13 April 2021
20210413 - Gardens of Peace - Response to Deadline 5 - Final

Gardens of Peace Muslim Cemetery (Plot 1/8) – Response to Deadline 5

1. Response to ExA’s Written Questions 2

PROPOSED WORKS INSIDE
CEMETERY

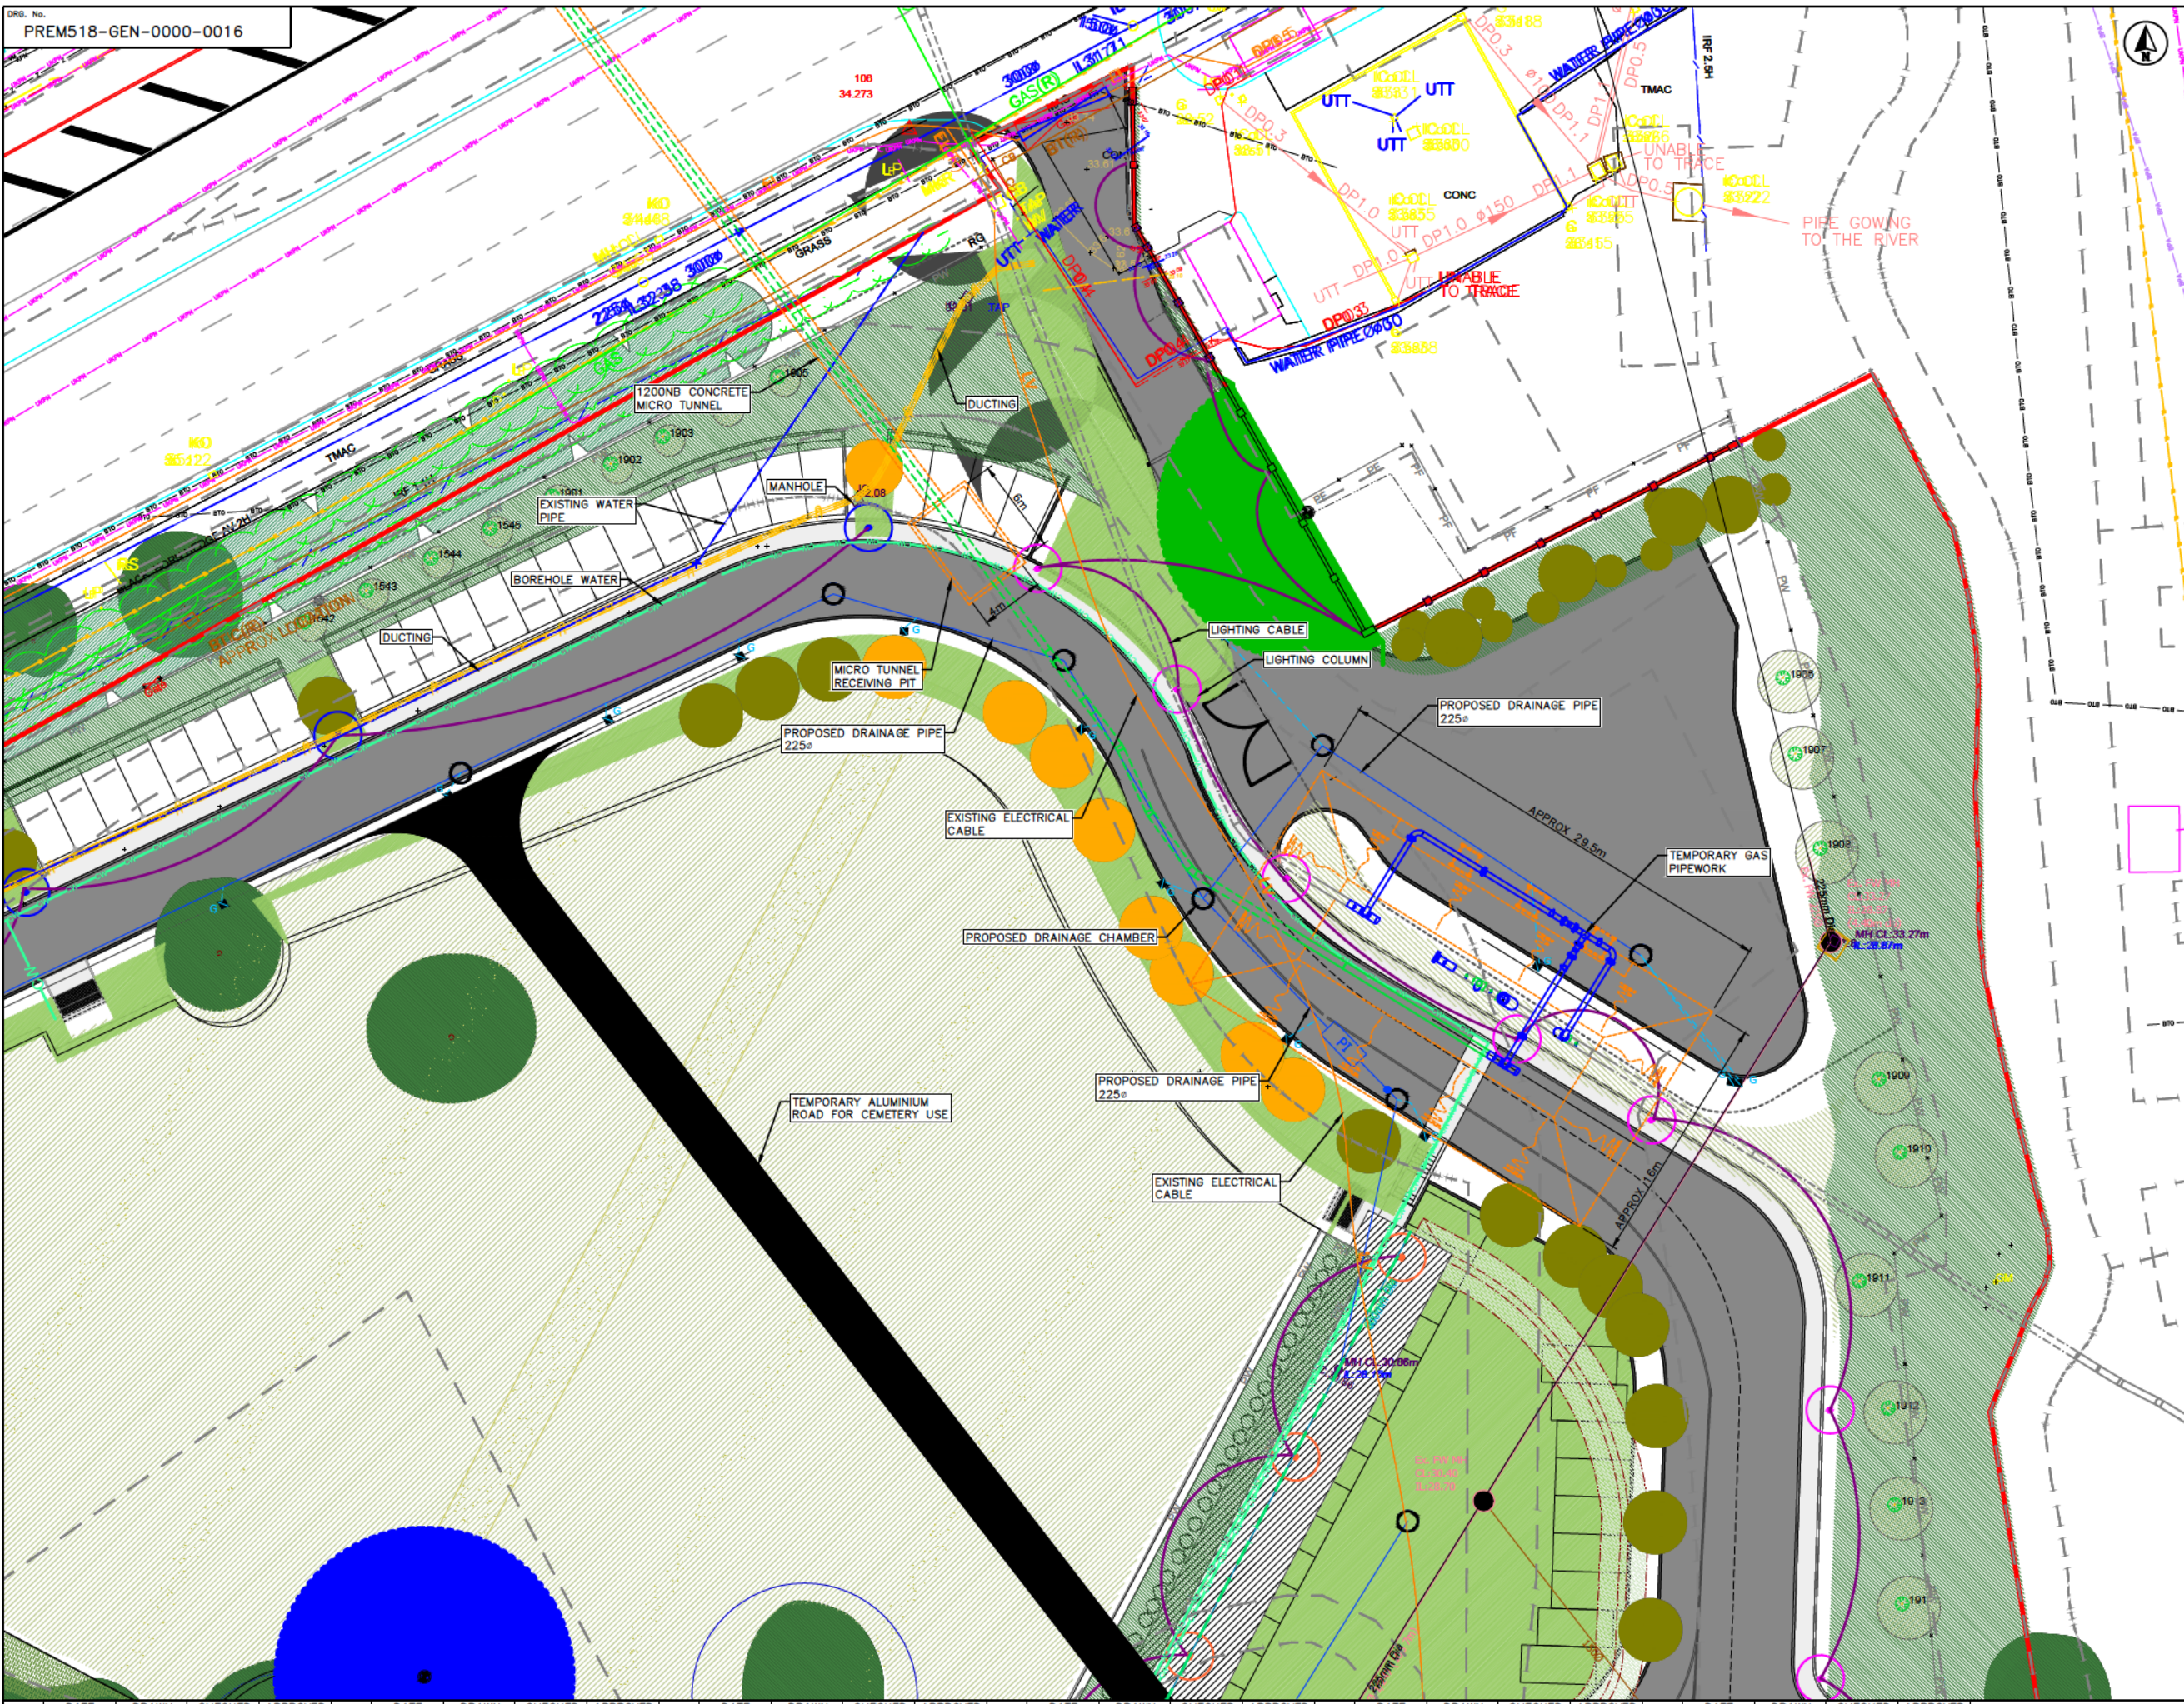
7. **Plot 1/8 Fencing** – Whilst the work plans prepared by Cadent following the recent site meeting confirm that Plot 1/8 will be bounded by Heras fencing, Gardens of Peace require that the Heras fencing running along the site boundary between the cemetery and Plot 1/8 is cladded with landscape designs to provide a visual barrier of the ongoing works of Plot 1/8 from the cemetery. It is also required that the fence cladding is of a form that acts as an acoustic barrier, to prevent any noise disruption from the works site on any burials.

12. **Drainage Provisions** – The draft Heads of Terms does not make any provisions for a temporary drainage solution (both underground and surface water) to replace the existing drainage system that falls within and is affected by Plot 1/8 and associated construction works. The existing drainage system prevents contamination of and silt deposits within the adjoining watercourse and thus it is fundamental a temporary solution is designed and agreed ahead of finalising the Heads of Terms.

#### 9.59 Overlay plan of Plot 1/8 and the burial plots

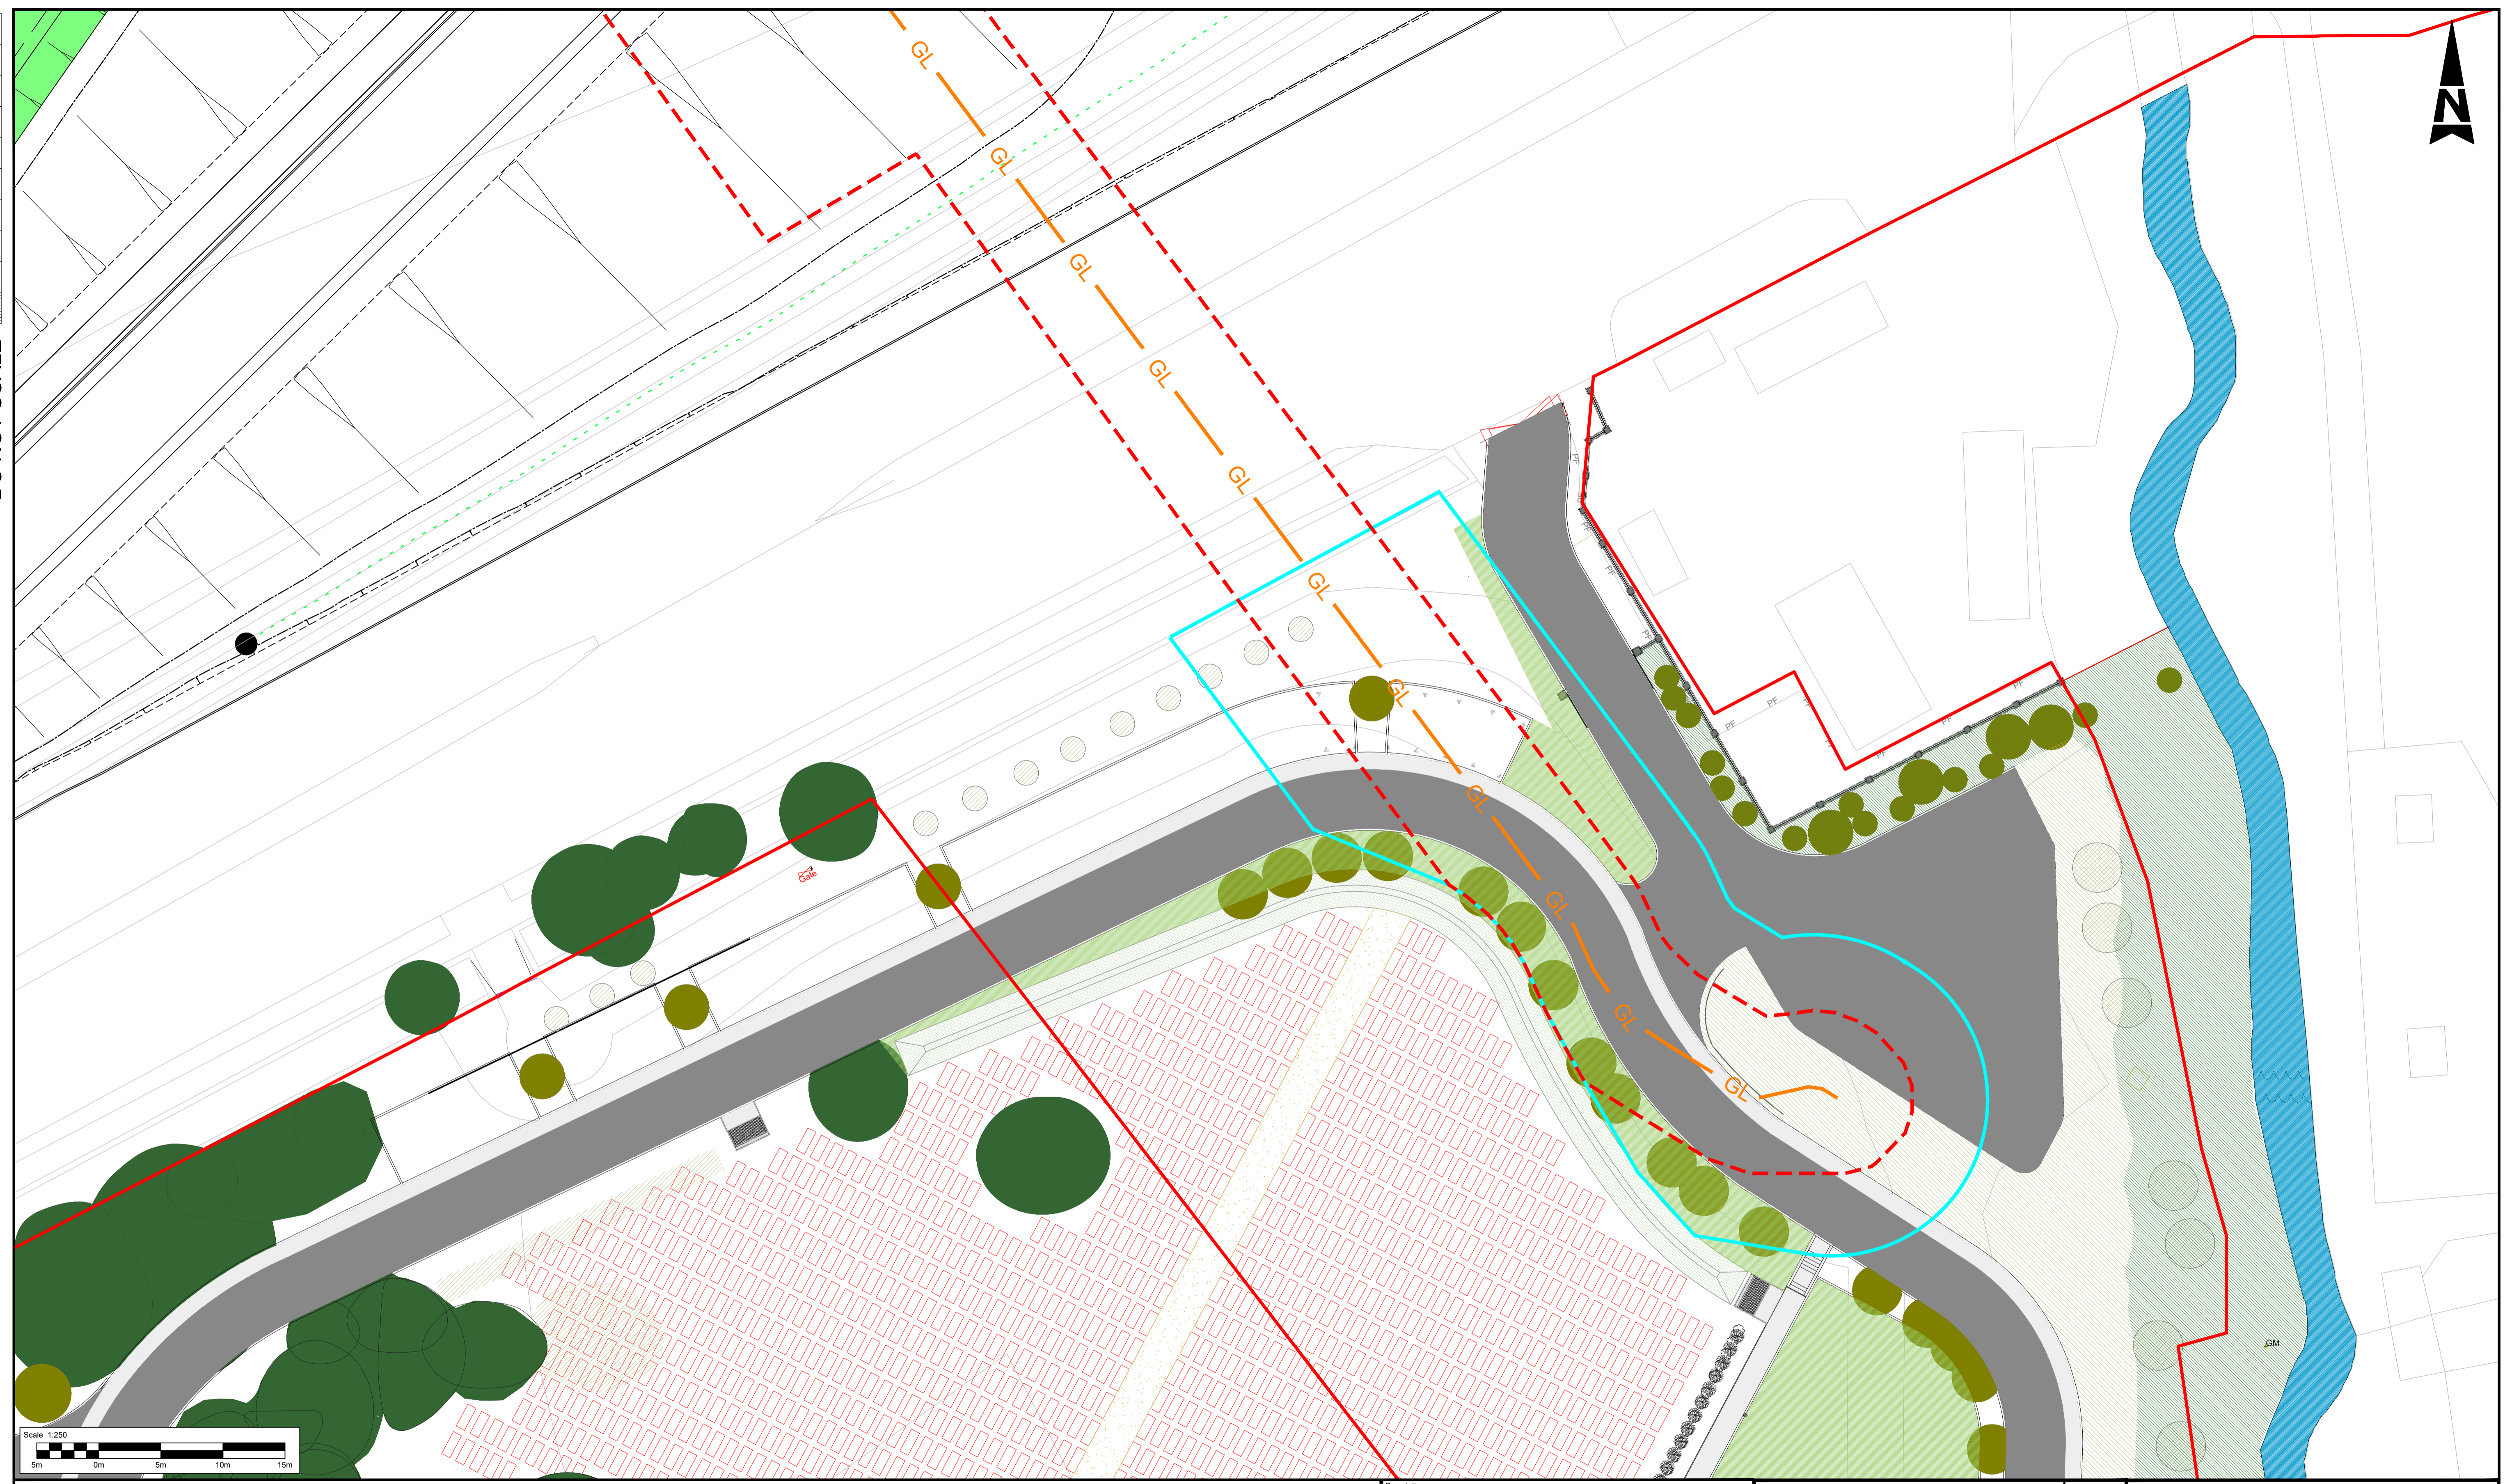
- ii) *Respond to the Gardens of Peace Muslim Cemetery Overlay Plan submitted at Deadline 4 [REP4-020].*

Gardens of Peace welcome the changes to the reduction in area subject to acquisition of permanent rights over Plot 1/8. As a result of these changes, there will be no overlap of the easement width and the land identified for burial use, thus all land will be reinstated to its intended use post Scheme completion. Gardens of Peace has also been informed during a call with Cadent Gas, that due to the need to bore under the A12, the limit of deviation is very minimal and thus there will be no unintended deviation outside the limits identified on the plan submitted at Deadline 4 (Application Document Reference TR010029/EXAM/9.59).
